ATP Locomotive Workshop (Bays 5 - 15) (SSD-8449-Mod-4)
Request for Additional Information

I refer to the modification application for alterations to the internal design and layout of Bays 5 – 15 of the Locomotive Workshop (SSD-8449-Mod-4).

Schedule 1 – Additional information

3 L2 - GFA - BAYS 5-15
1 : 500

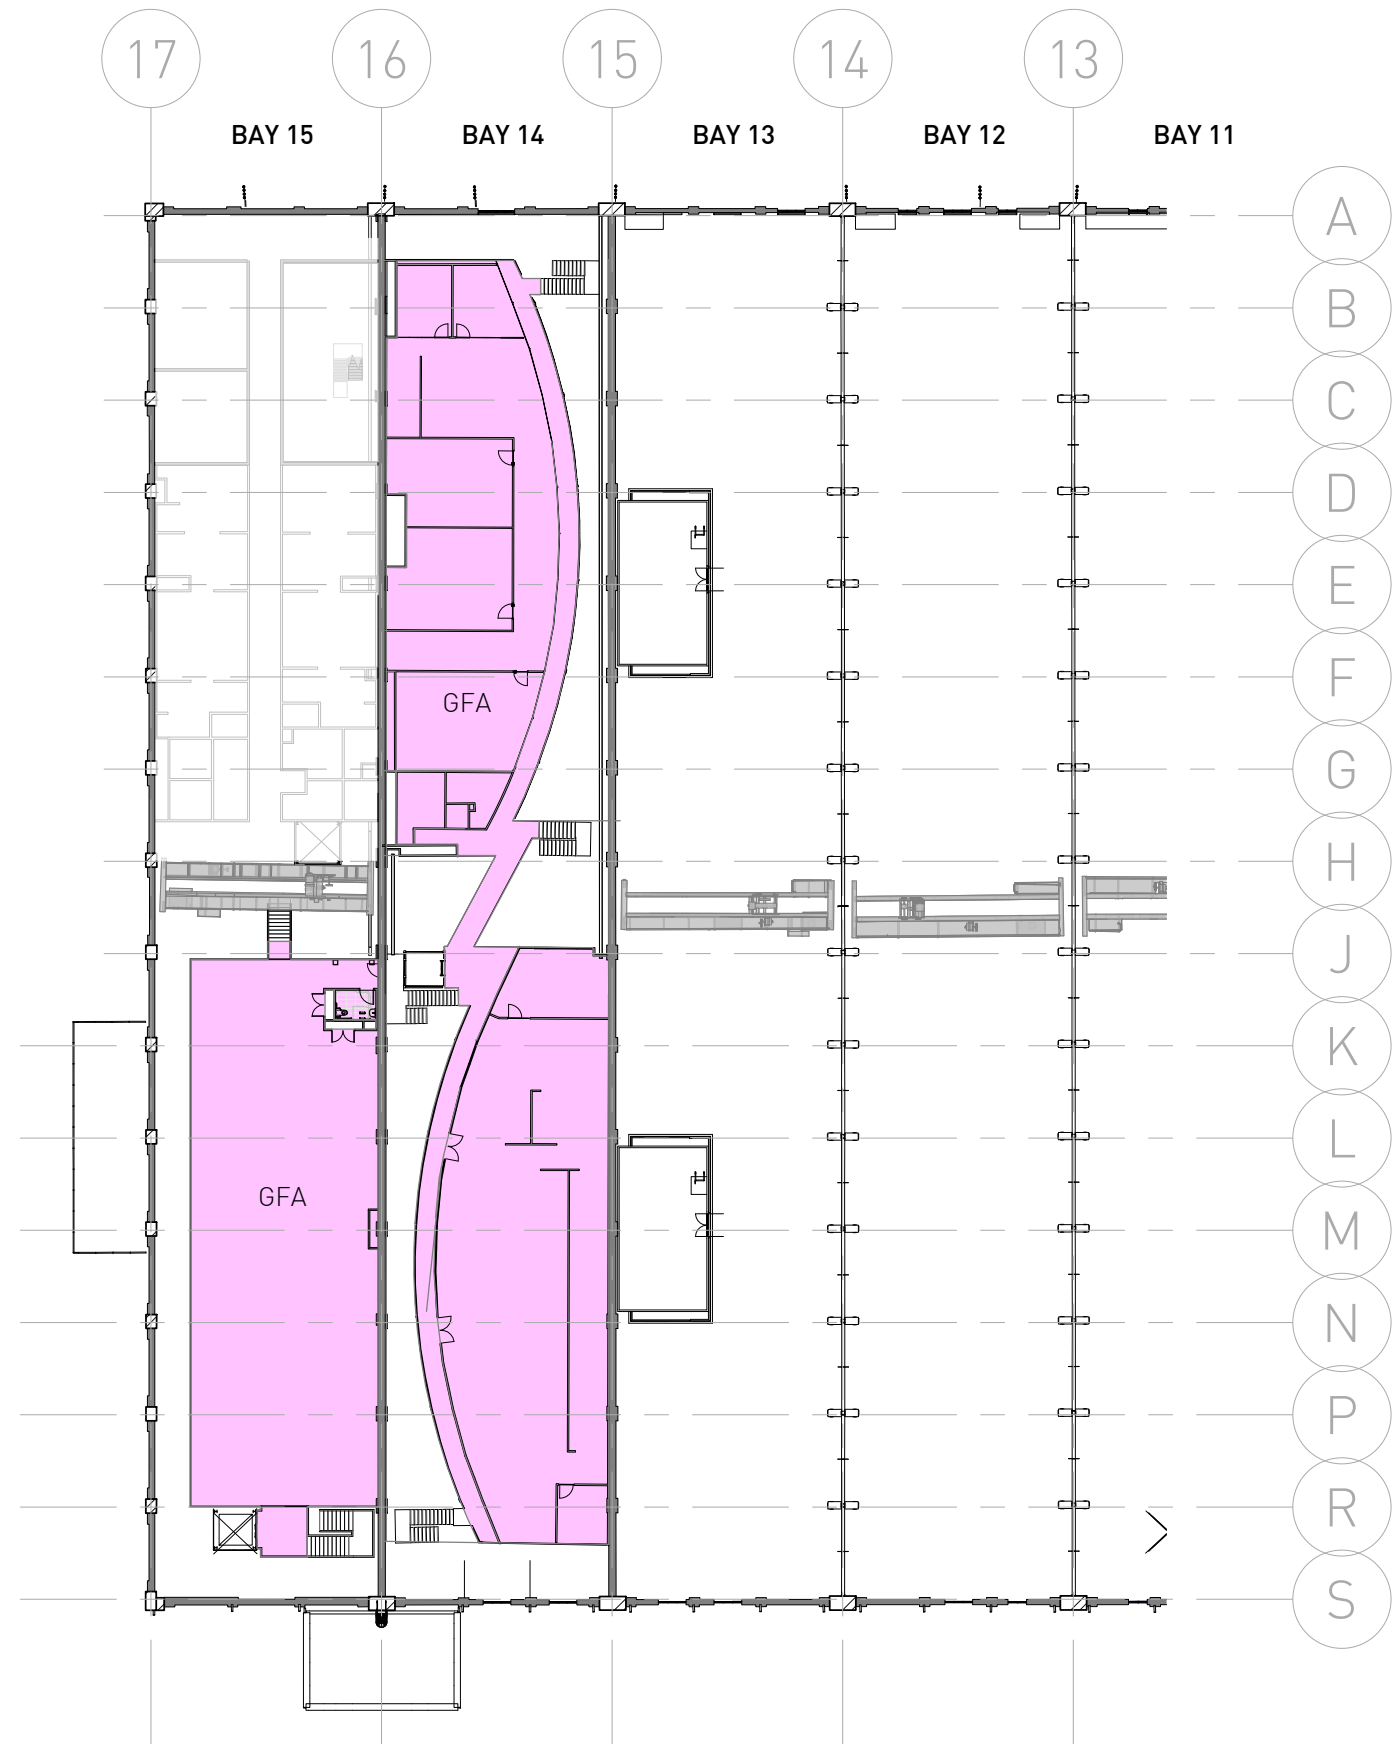
- Identify the material proposed for the intertenancy wall that is proposed to be moved from gridline 9 to 10 (item 14).
- Confirm the GFA calculation changes from approved plan, SA-AR-DWG-BB-B4-0250 Rev T, to the submitted plan, SA-AR-DWG-BB-B4-0250 Rev U.
